2026 No. 842

INFRASTRUCTURE PLANNING

**The M25 Junction 10/A3 Wisley Interchange Development
Consent (Amendment) Order 2026**

Drawing Title: **SPEED LIMITS AND TRAFFIC REGULATIONS PLANS REGULATION 5(2)(o) SHEET 3 OF 9**

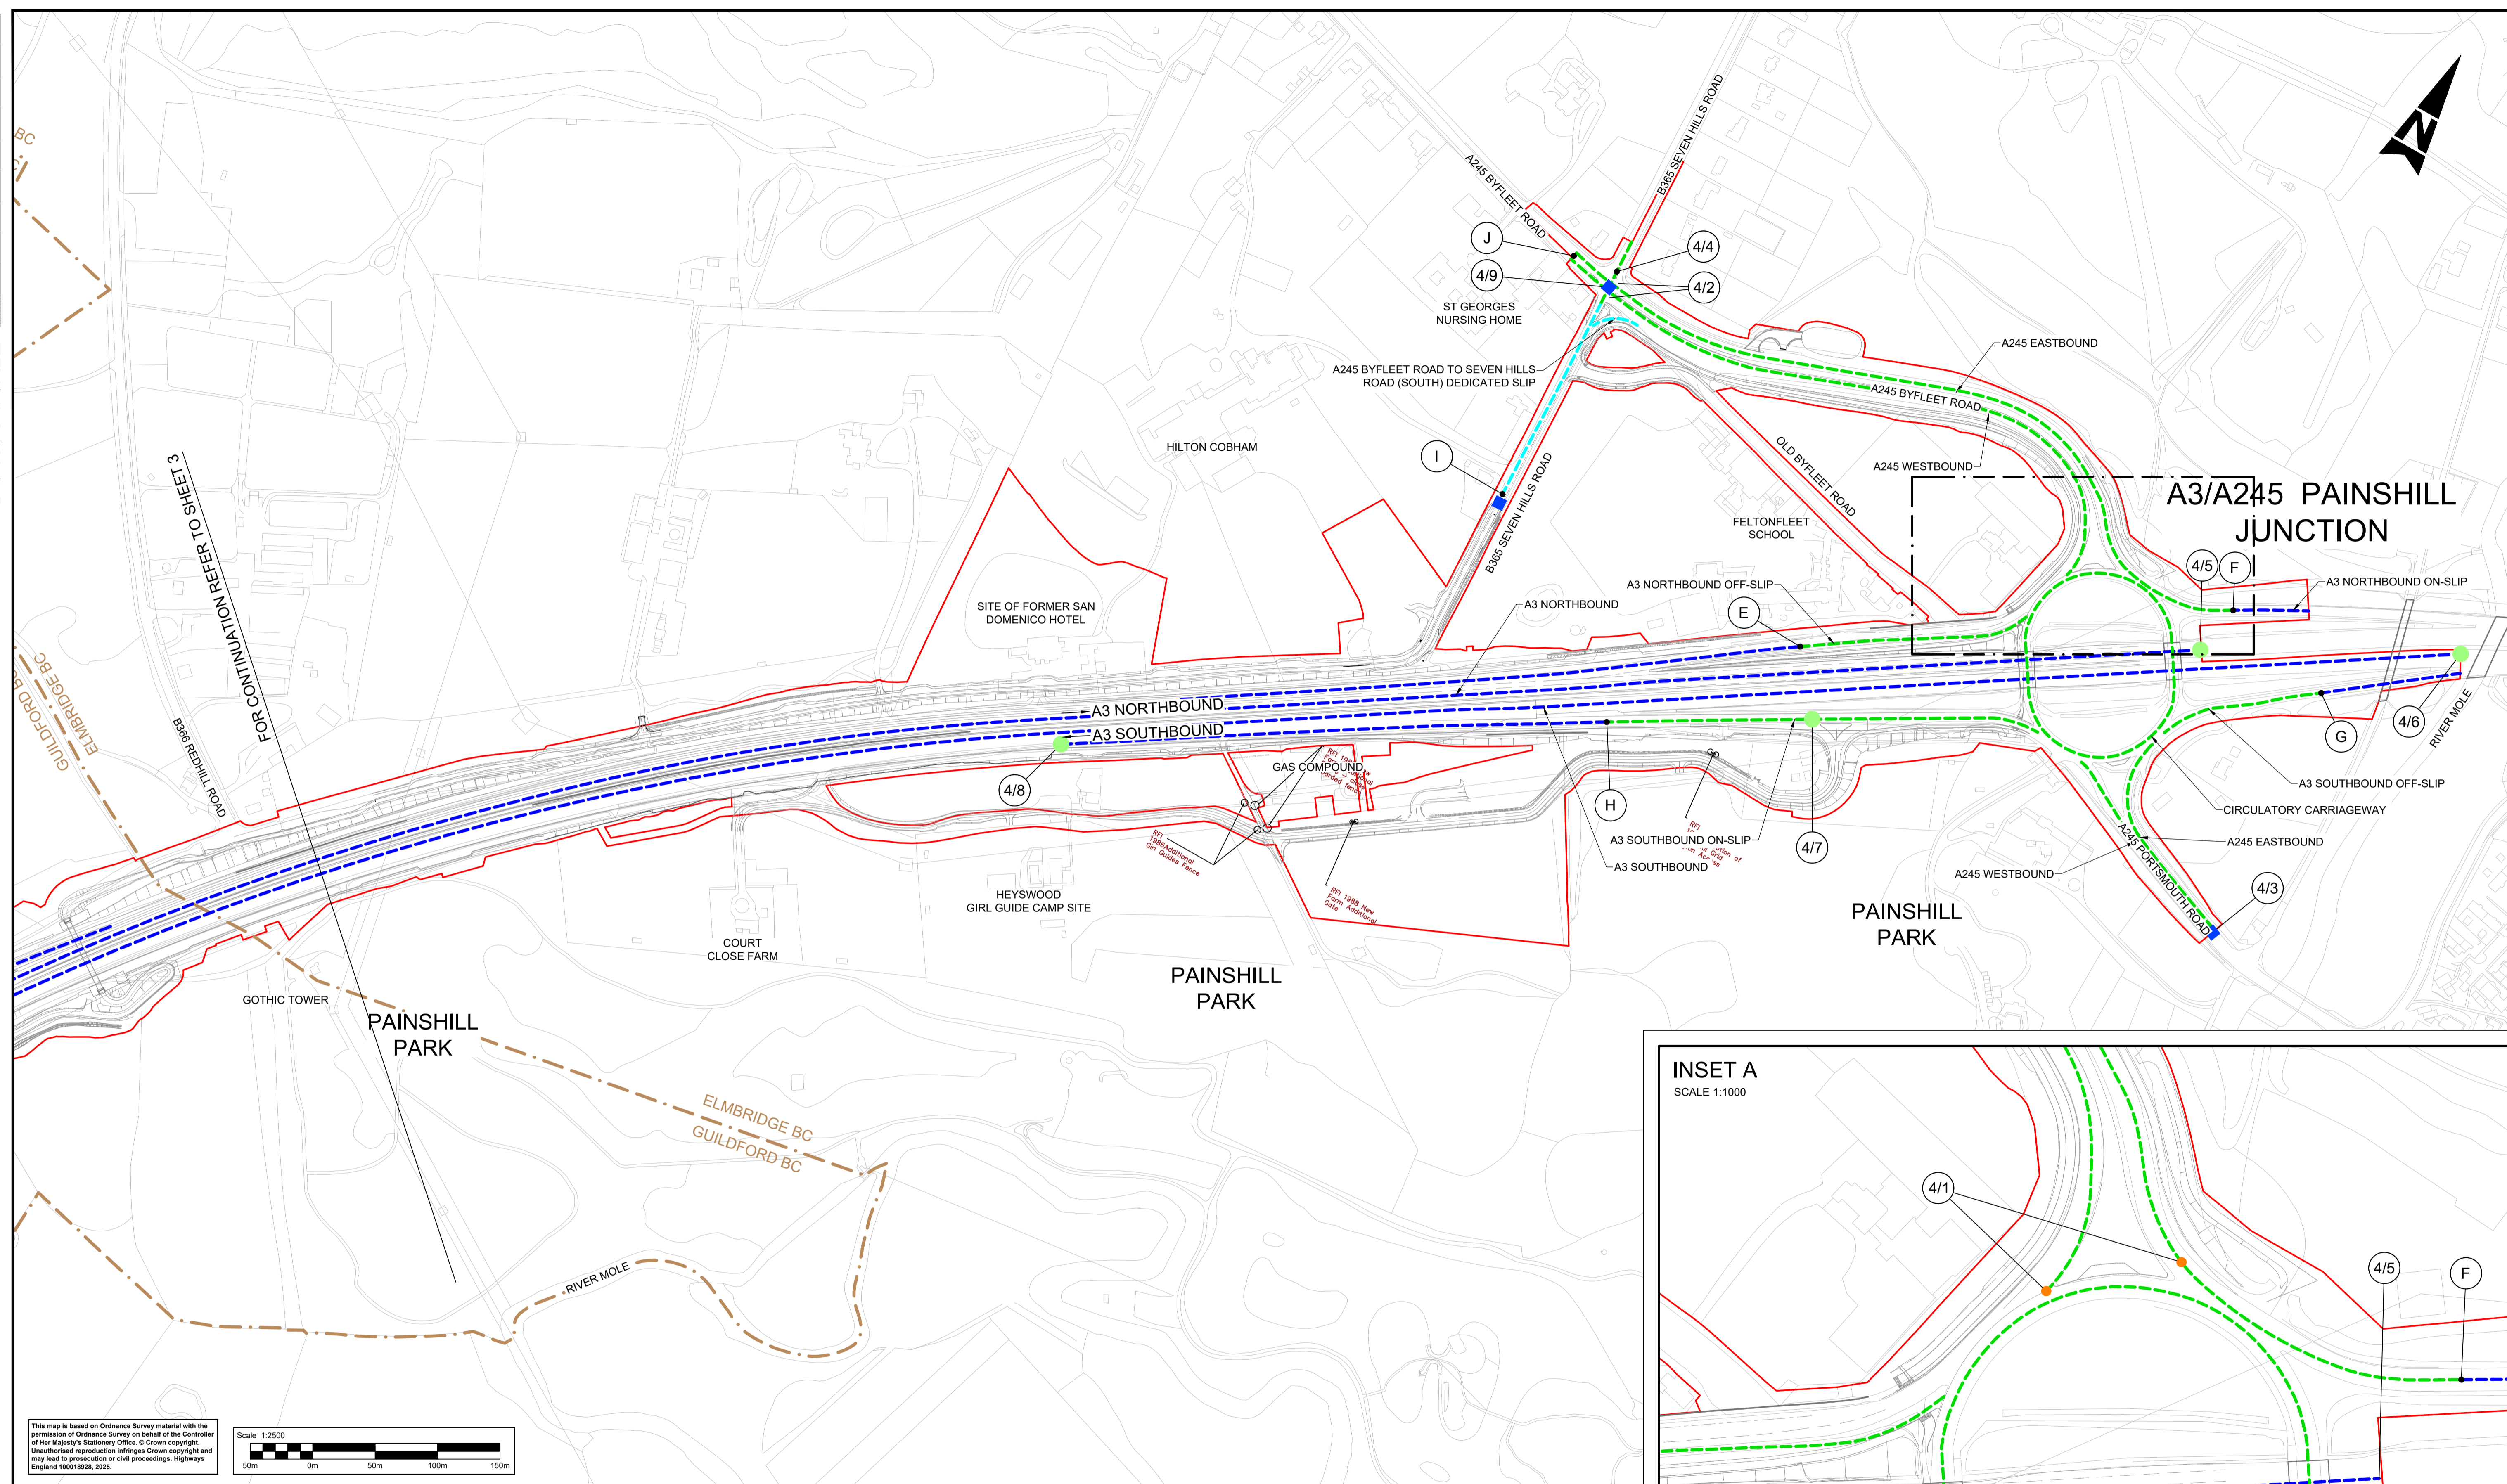
<i>(1) Road name and number</i>	<i>(2) Extent</i>	<i>(3) Speed Limit</i>
M25 eastbound	Along the length of the improved M25 eastbound carriageway, for a total distance of 5,580 metres, as shown on Sheets 3, 5, 7 and 9 of the speed limits and traffic regulations plans.	National speed limit (70 miles per hour, as existing limit)
M25 eastbound on-slip at M25 junction 10	Along the length of the altered slip road, from its diverge from the M25 junction 10 circulatory carriageway to its merge with the M25 eastbound carriageway, for a total distance of 955 metres, as shown on Sheets 3 and 7 of the speed limits and traffic regulations plans.	National speed limit (70 miles per hour, as existing limit)
M25 westbound	Along the length of the improved M25 westbound carriageway, for a total distance of 6,050 metres, as shown on Sheets 3, 5, 7 and 9 of the speed limits and traffic regulations plans.	National speed limit (70 miles per hour, as existing limit)

M25 westbound on-slip at M25 junction 10	Along the length of the improved slip road, from its diverge from the M25 junction 10 circulatory carriageway to its merge with the M25 westbound carriageway, for a total distance of 1,225 metres, as shown on Sheets 3 and 5 of the speed limits and traffic regulations plans.	National speed limit (70 miles per hour, as existing limit)
A3 northbound to A245 westbound dedicated slip lane at the A3 Painshill junction	Along the length of the new slip road, from its diverge from the A3 northbound off-slip to its merge with the A245 westbound carriageway, for a total distance of 180 metres, as shown on Sheet 4 of the speed limits and traffic regulations plans.	40 miles per hour

The table in Part 5 of Schedule 3 is amended to remove entries prescribing certain speed limits, and to remove reference to a road to which works are no longer proposed to be carried out. Speed limits for the M25 carriageway, the two free-flow slip lanes for traffic entering the M25 and the M25 on-slip roads are prescribed under the M25 Motorway (Junctions 7 to 16) (Variable Speed Limits) Regulations 2012 (S.I. 2012/2134).

Project Title	M25 JUNCTION 10 / A3 WISLEY INTERCHANGE IMPROVEMENT
Drawing Title	SPEED LIMITS AND TRAFFIC REGULATIONS PLANS REGULATION 5(2)(o) SHEET 4 OF 9
Drawing Number	HE551522
Project	BBA - LDC - WHL_ML_A3 - DR - ZL - 020704
Location	A1
Scale	1:2500
Project Ref. No.	5195939
Sheet	4 of 9
Rev	P02

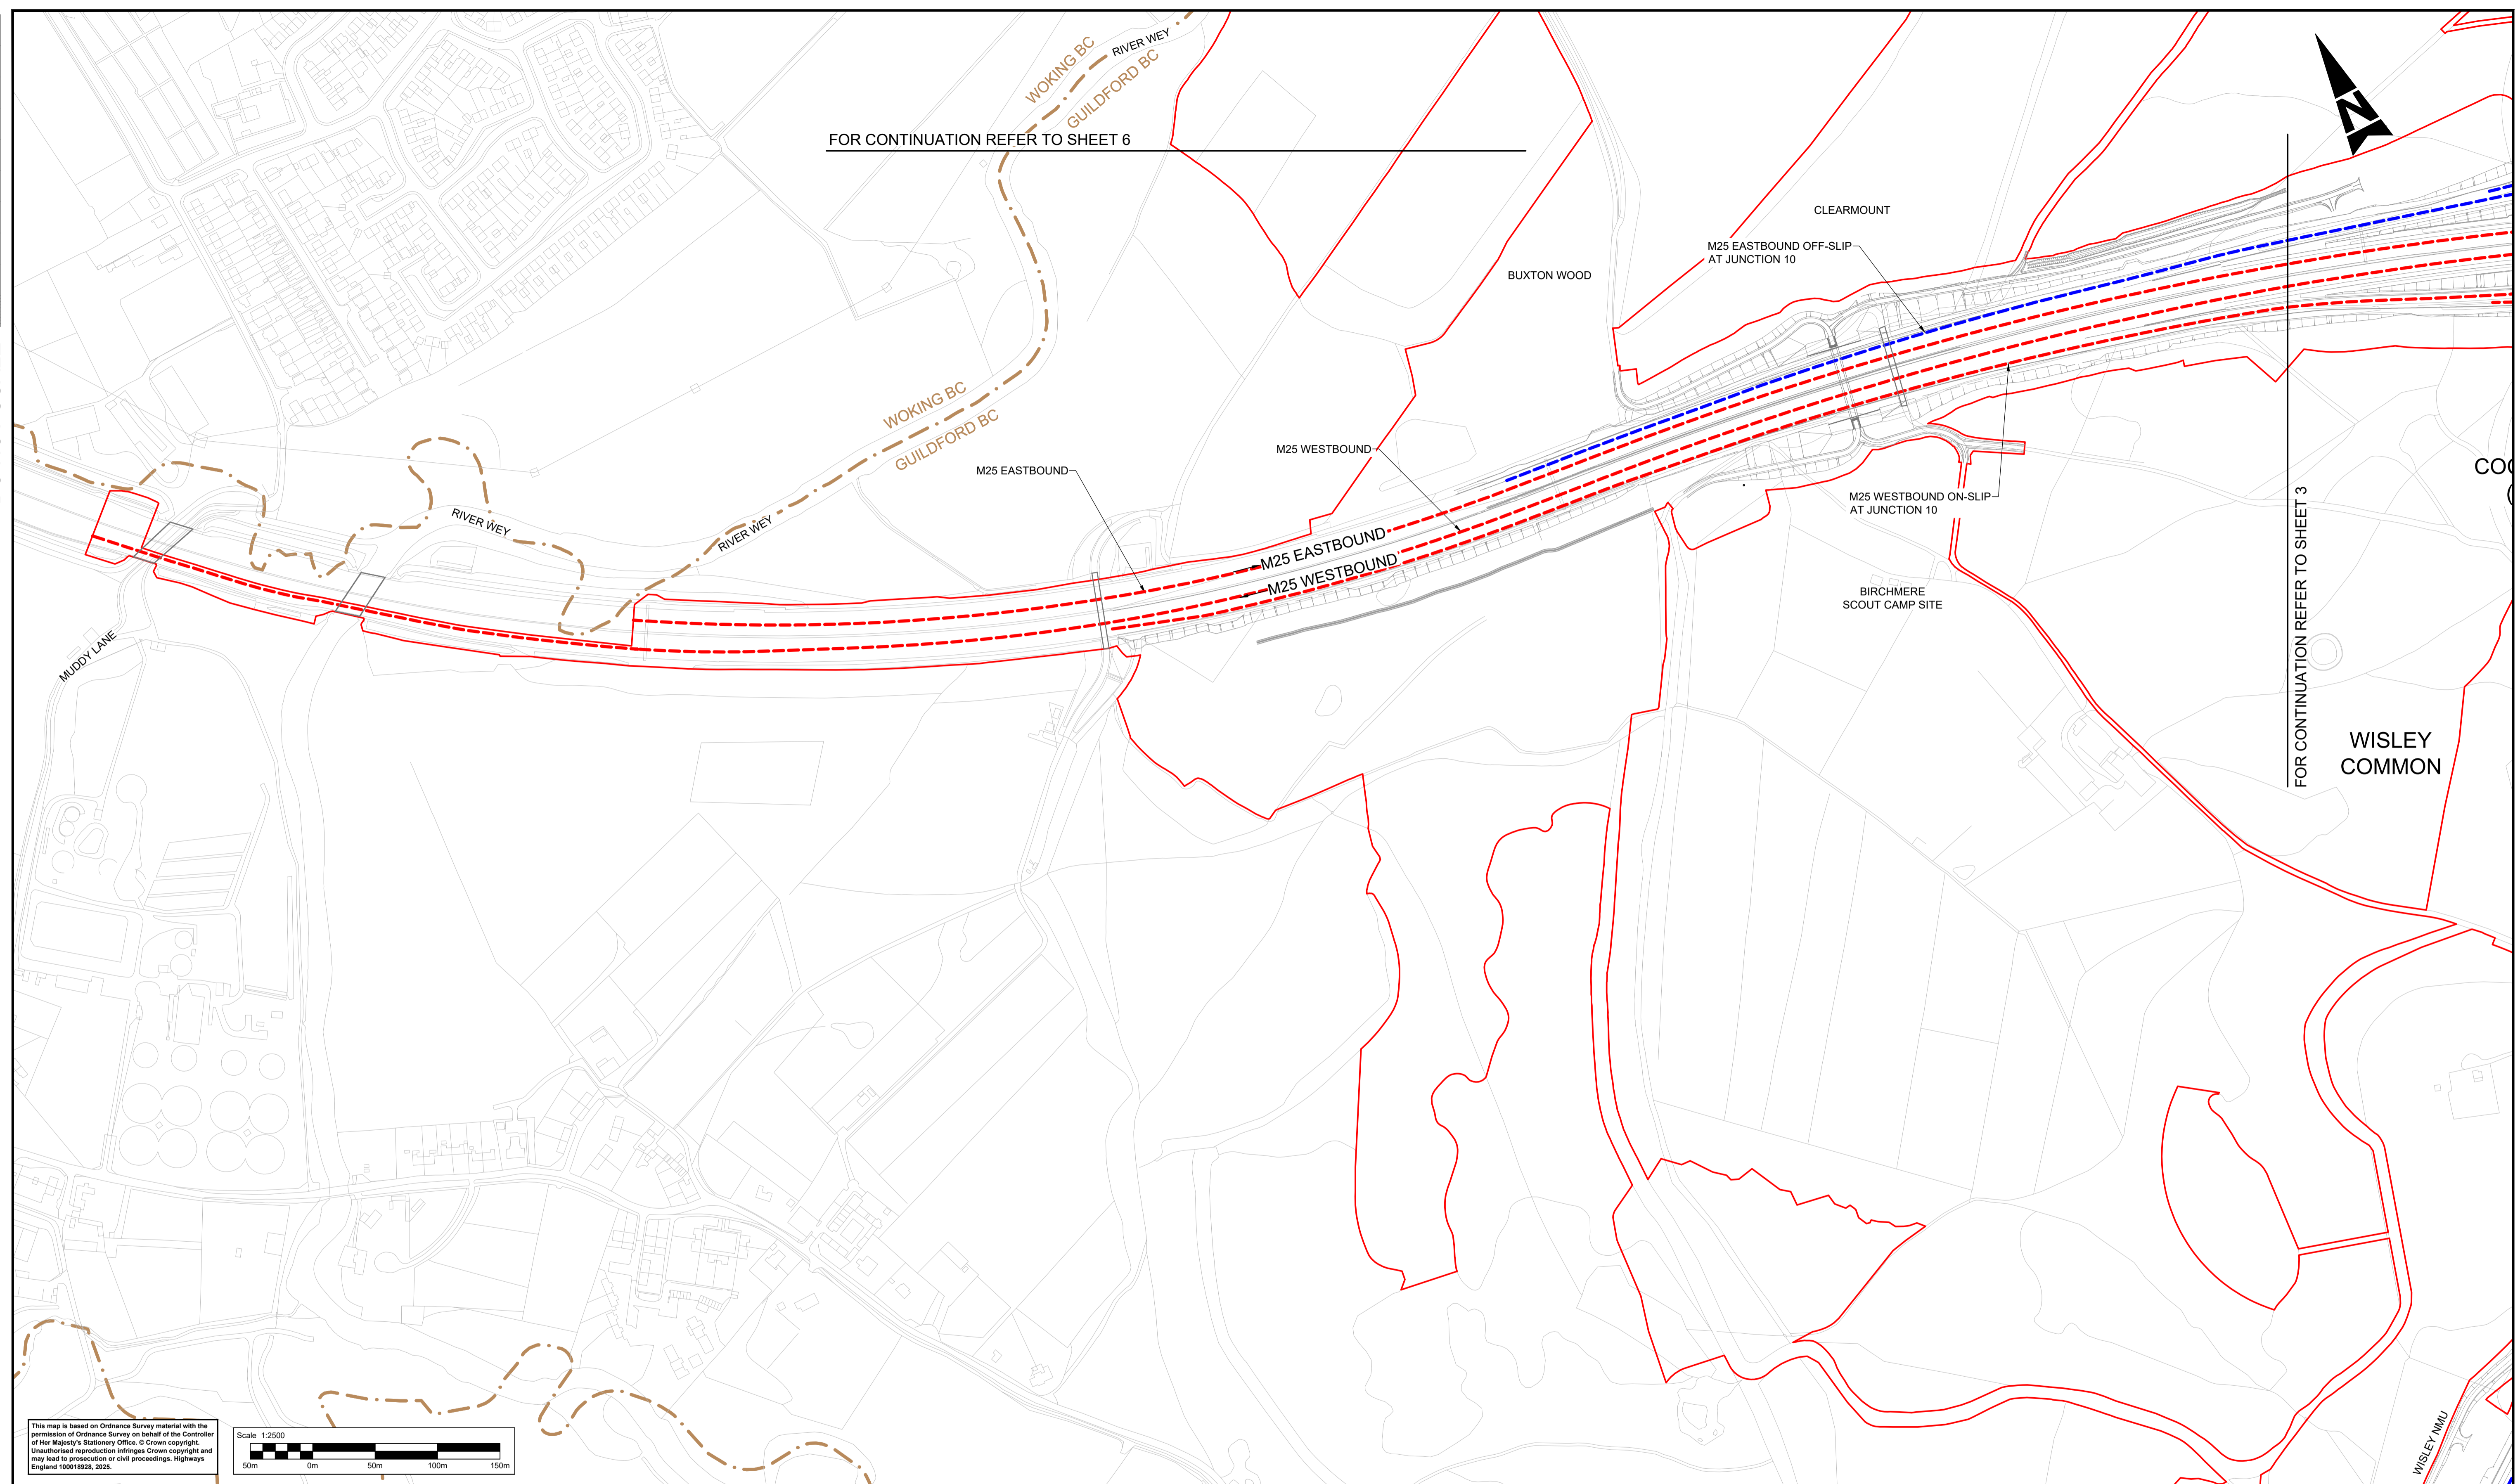
- (a) in the row relating to the “A3 northbound to M25 westbound dedicated free-flow slip lane at M25 junction 10”, in column (2) for “205” substitute “39.12”; and
- (b) in the row relating to the “A3 southbound to M25 eastbound dedicated free-flow slip lane at M25 junction 10”, in column (2) for “210” substitute “45.25”.
